**Environmental Impact Statement, Sirius Development, 2-60 Cumberland Street,
The Rocks – SSD 10384**

Place Management NSW have reviewed the Environmental Impact Statement (EIS) for the restoration and refurbishment of the Sirius Site (State Significant Development Application – SSD 10384) and ask that you consider our comments and recommendation provided in the attached document.

PMNSW Response to Environmental Impact Statement – SSD 10384

DWG. TITLE  
**Landscape Plan - BASEMENT B2-B1**

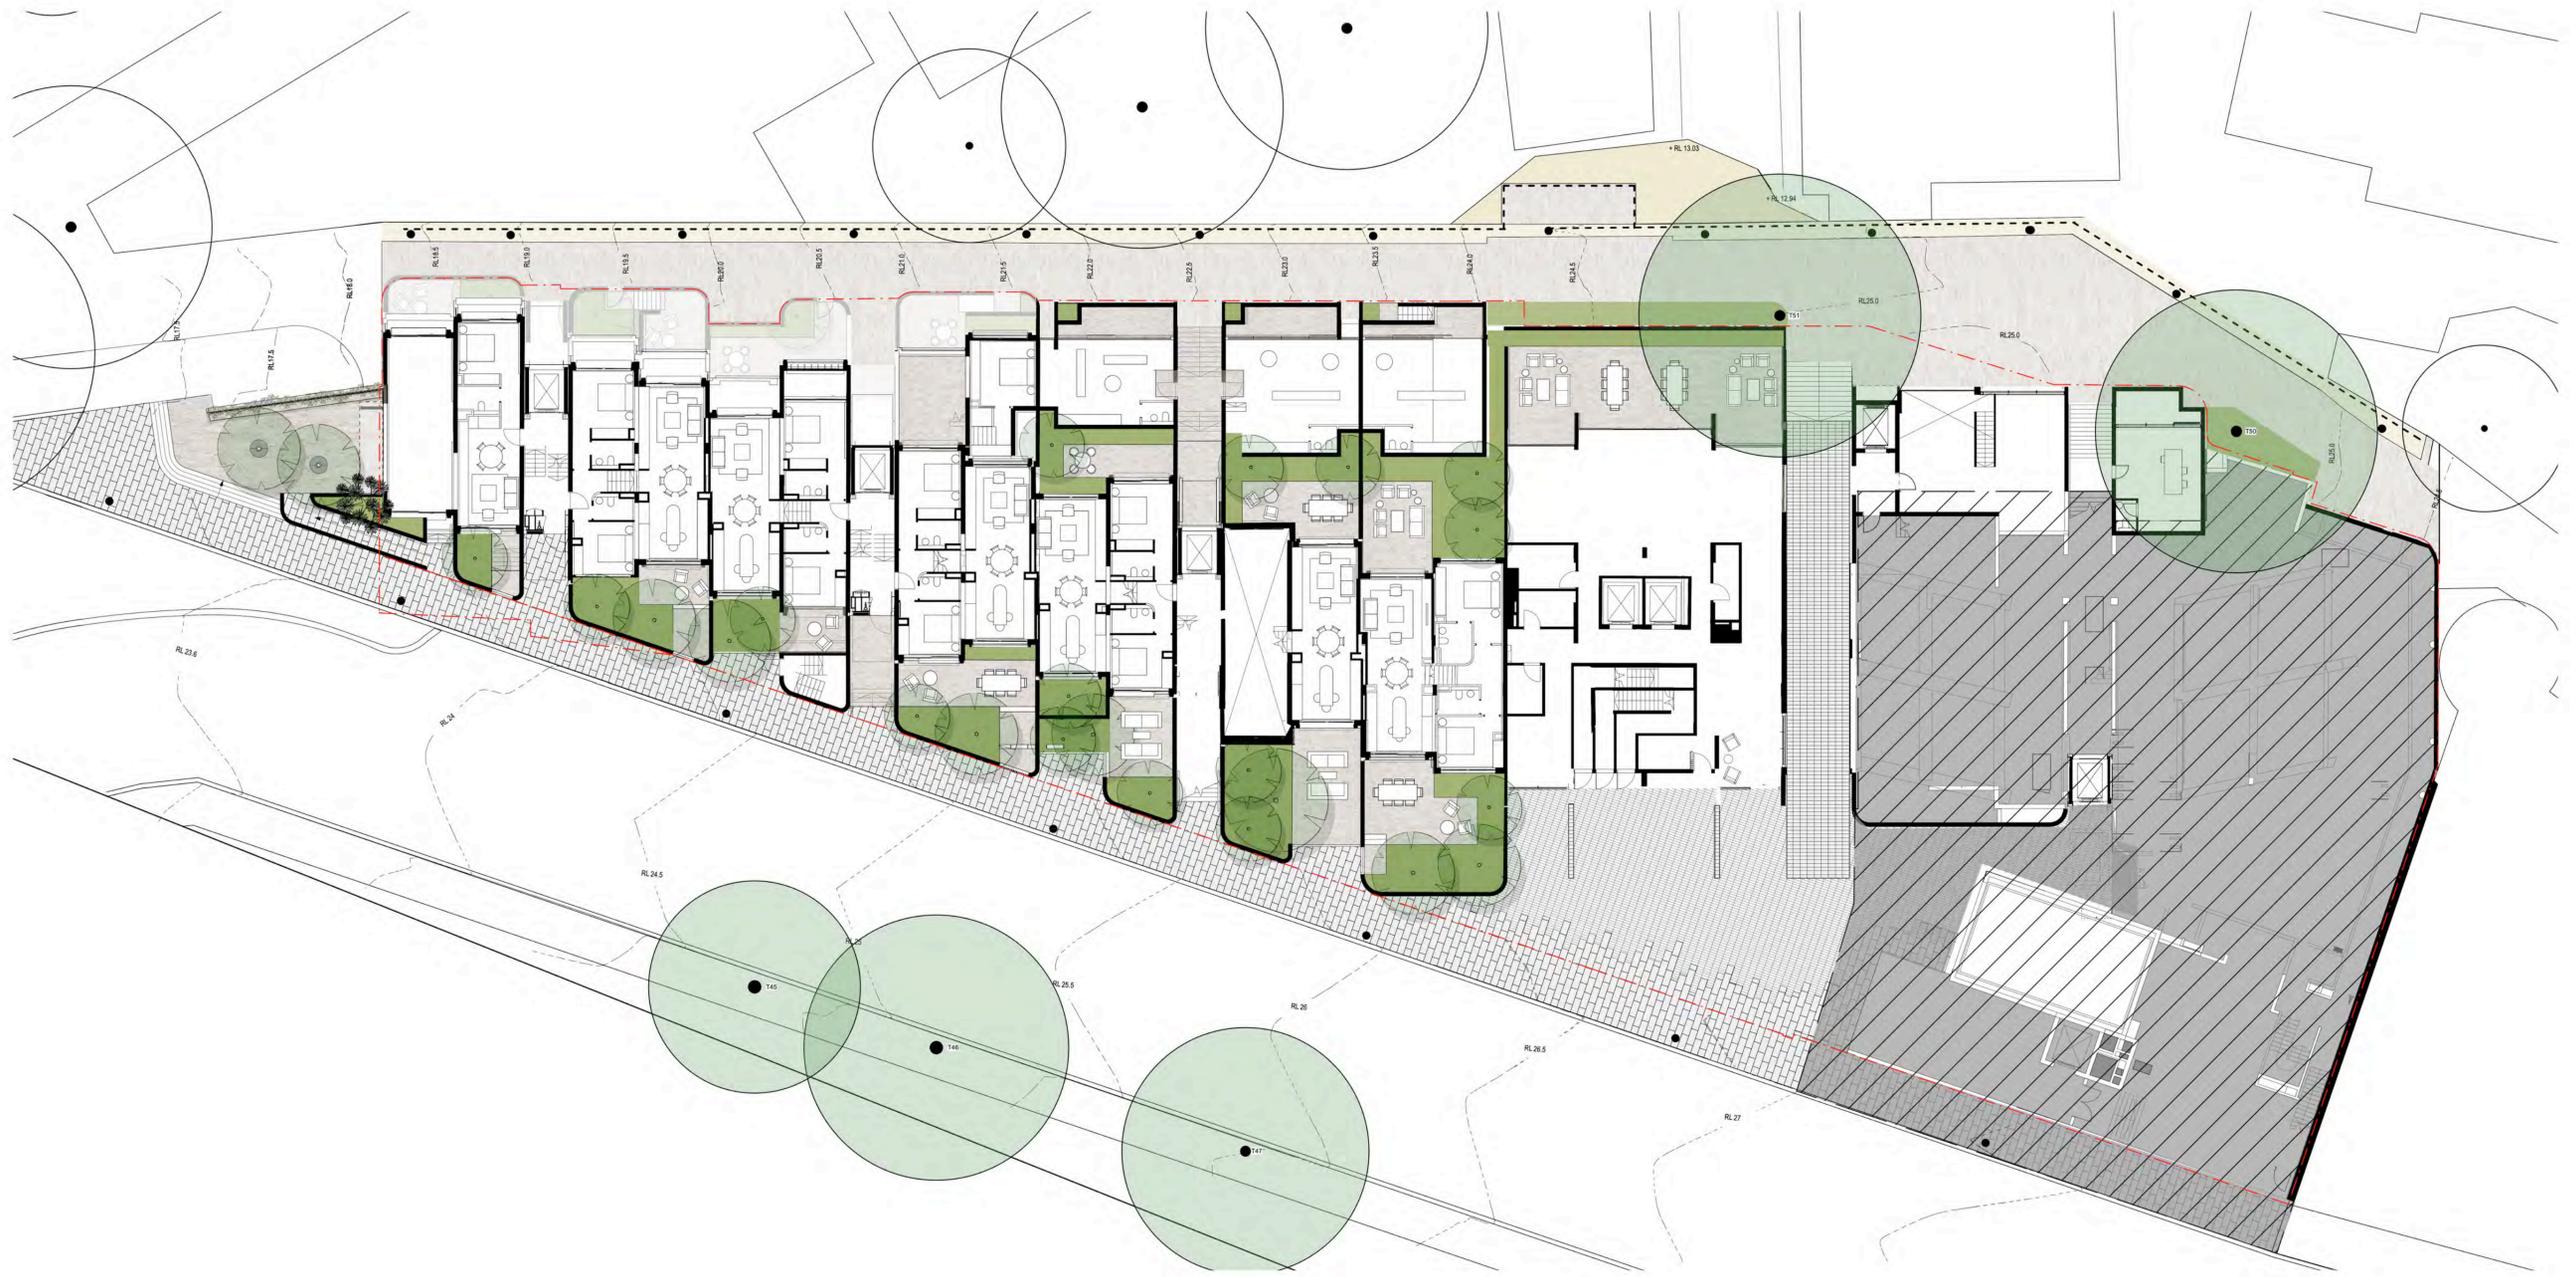
<p>The moderate impacts as noted in the VIA are acceptable and do not require any mitigation.</p> <p>The perspectives indicate green walls on the facade facing Gloucester walk - on Soho Style commercial / residential as well as the through link. These are not referenced in the landscaping report or drawings.</p> <p>This green is beneficial to soften the building and improve amenity to Gloucester walk and should be retained</p>	
Historical Archaeological Assessment (Appendix P)	<p>Section 4 does not take into account significant archaeological findings on the sites directly adjacent to the south (Immigration House and Glenmore Hotel), and does not examine the historic photographic evidence indicating the siting and nature of the early 19th century buildings that formerly fronted Gloucester Street (Walk).</p> <ul style="list-style-type: none"> • 2.2.1 does not clearly state that the site <u>is</u> subject to the archaeological requirements of s139 of the Heritage Act since Sirius is not identified as an item on the State Heritage Register (s60) • There is a difference of approximately 4-5 metres between the Cumberland and Gloucester frontages, and it has therefore been assumed by the authors that the bedrock was quarried in relatively modern times. Evidence along this ridge indicates terracing dating from as early as 1820, dividing properties facing Cumberland Street from those fronting Gloucester Street. • The extent of site excavation in the late 1970s for the current building is unclear. The current basement carpark floor is on a similar level with Gloucester Walk. Pre-1900 photographs and other evidence indicates on-grade access from the former houses that stood on this site onto Gloucester Walk (formerly Gloucester 	<ul style="list-style-type: none"> • It is therefore recommended that further archaeological assessment, including historical research, is undertaken for the site, with particular reference to the areas of proposed disturbance. • Assessment should include exploratory test excavation at the earliest convenience to assist in identifying potential archaeological deposits and determining appropriate methodologies for treatment of the resource. All archaeological investigation should be undertaken in accordance with the NSW Heritage Act (1977), Division 9.
